Application No: WA/50/20/RES
Site Address: Former Lanes End House West Walberton Lane Walberton BN18 0QS
Description of works: Approval of reserved matters following outline consent WA/26/18/OUT for appearance, landscaping, layout & scale for the demolition of 1 No. dwelling & the erection of 6 No. dwellings (resubmission following WA/7/19/RES).

Thank you for your internet representation made on 25th October 2020 which has been recorded as an objection with the comments as follows:

PLOT 6
FLOOR PLANS AND
ELEVATIONS

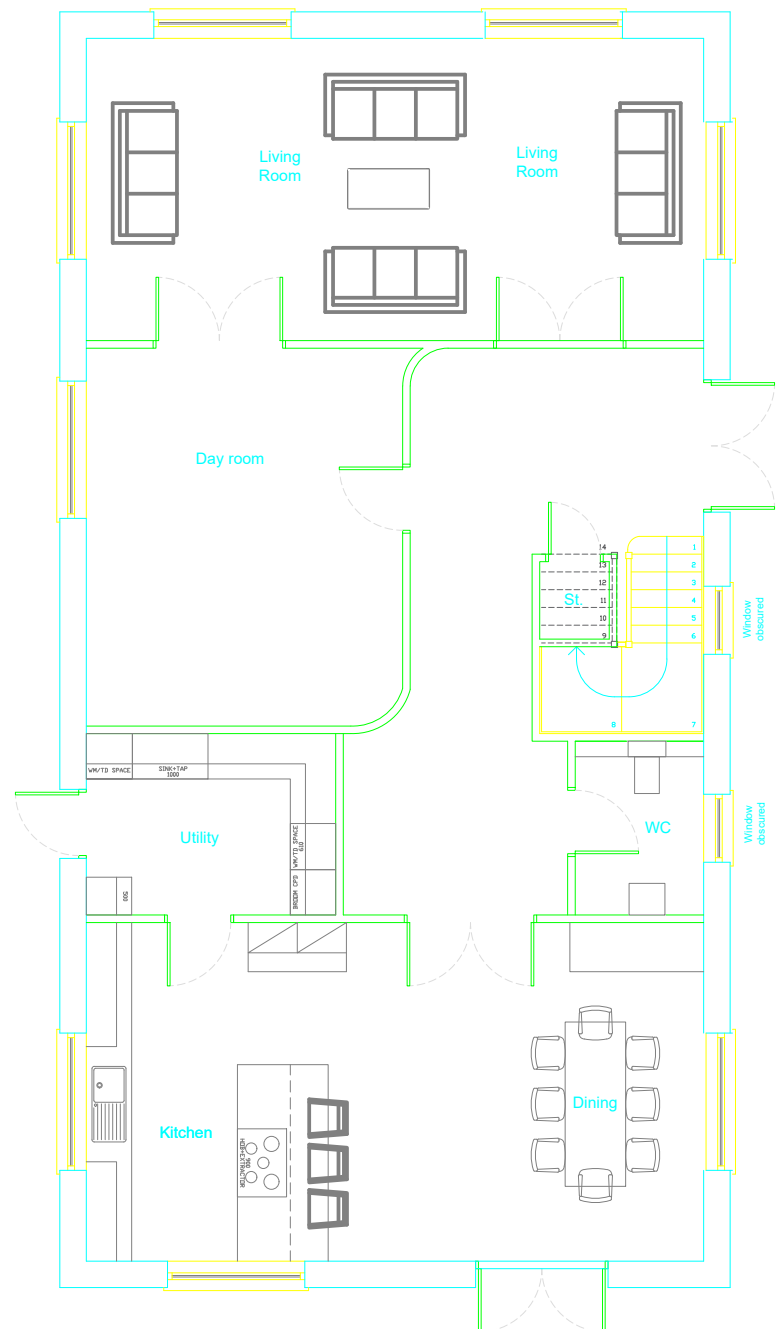
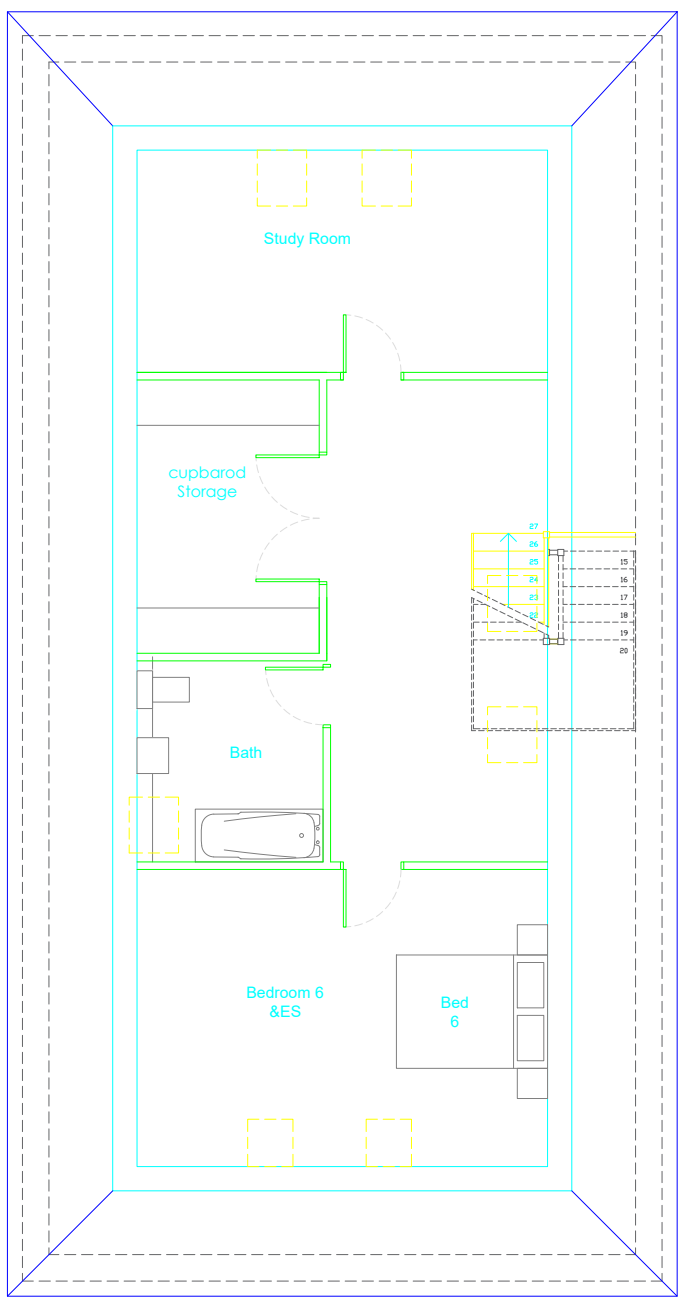
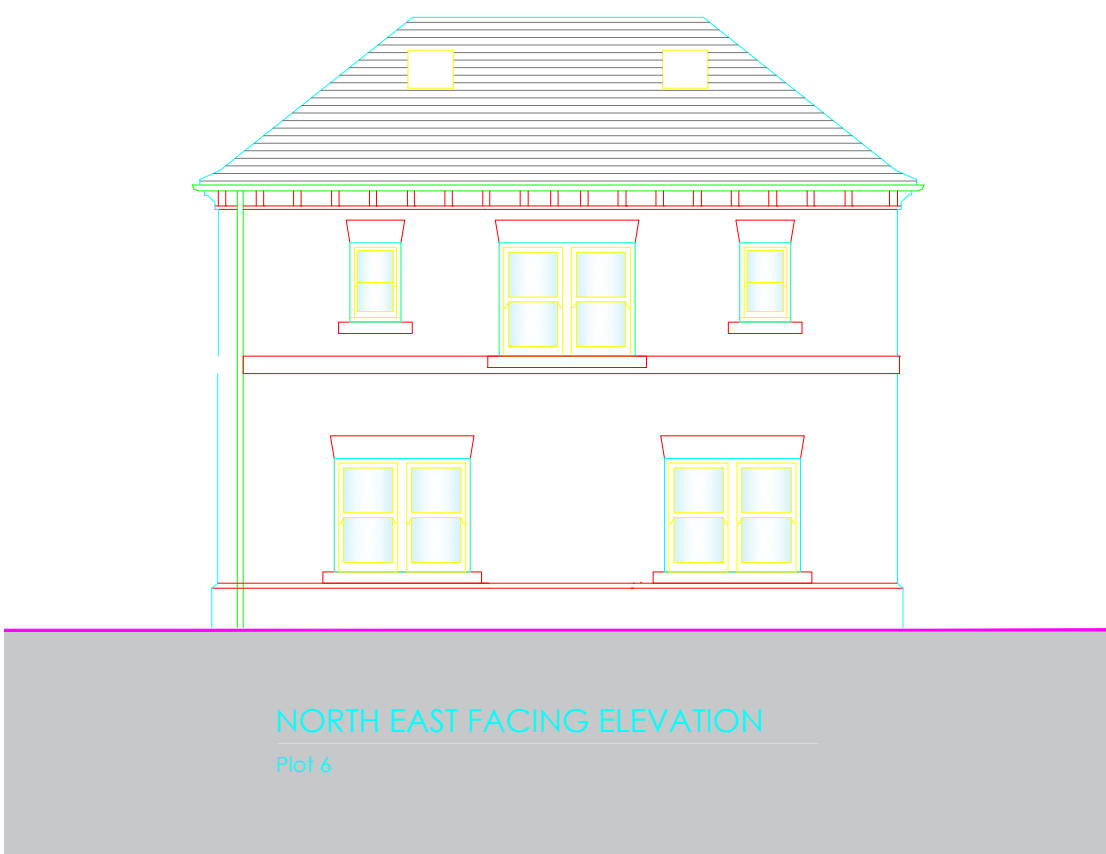
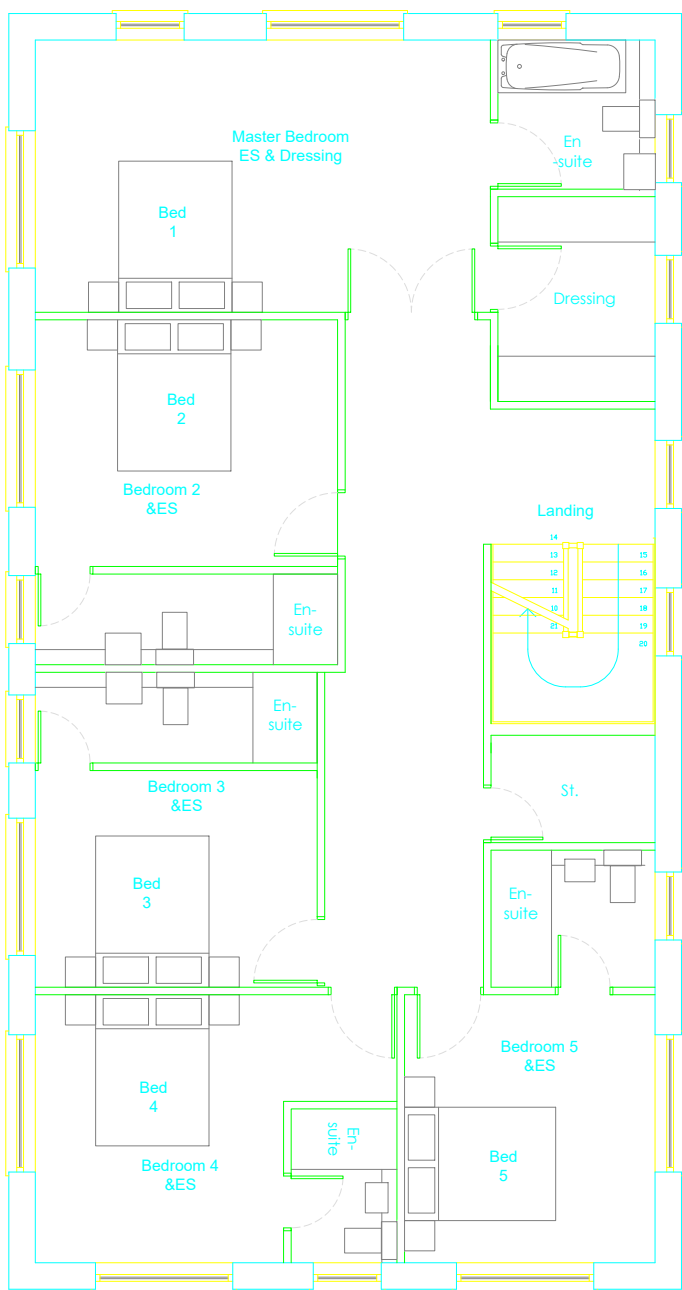
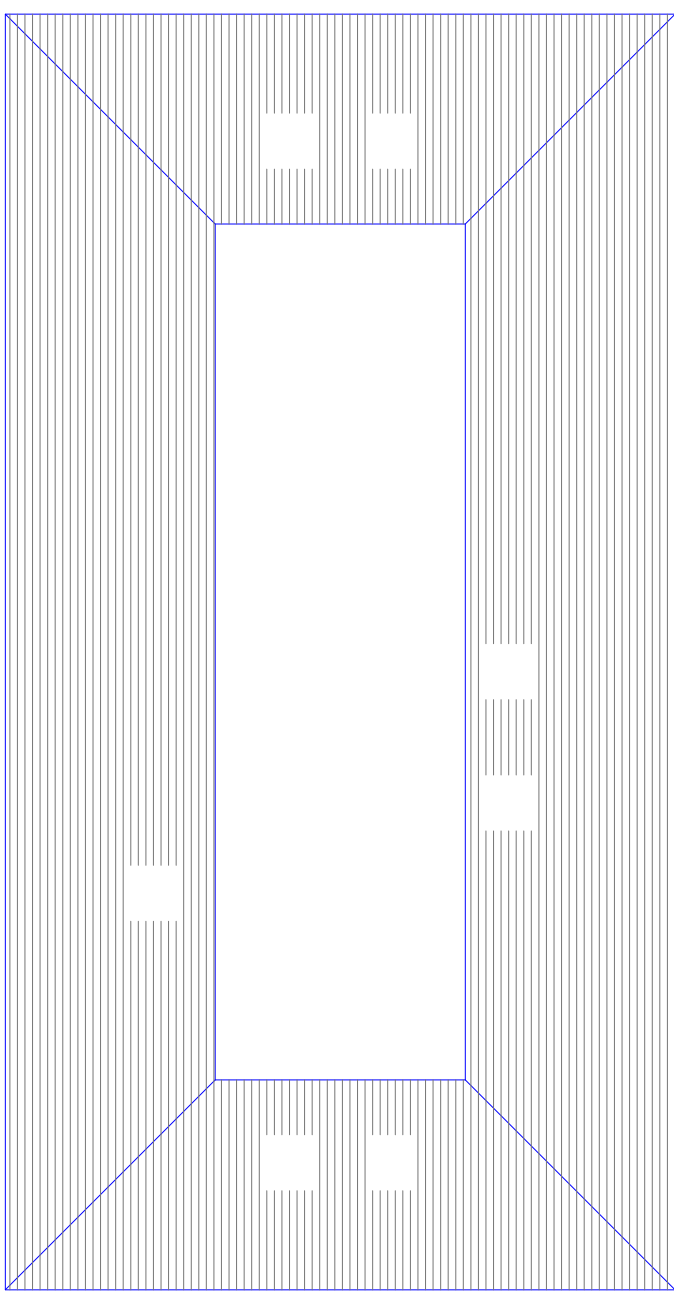
Inconsistency between drawings for Unit(Plot) 6.

The windows of Unit 6 shown on the elevation facing Woodland gable end will allow direct visual intrusion into bedrooms at the west end and into the fully glazed conservatory unless they are made of obscure glazing and non-opening.
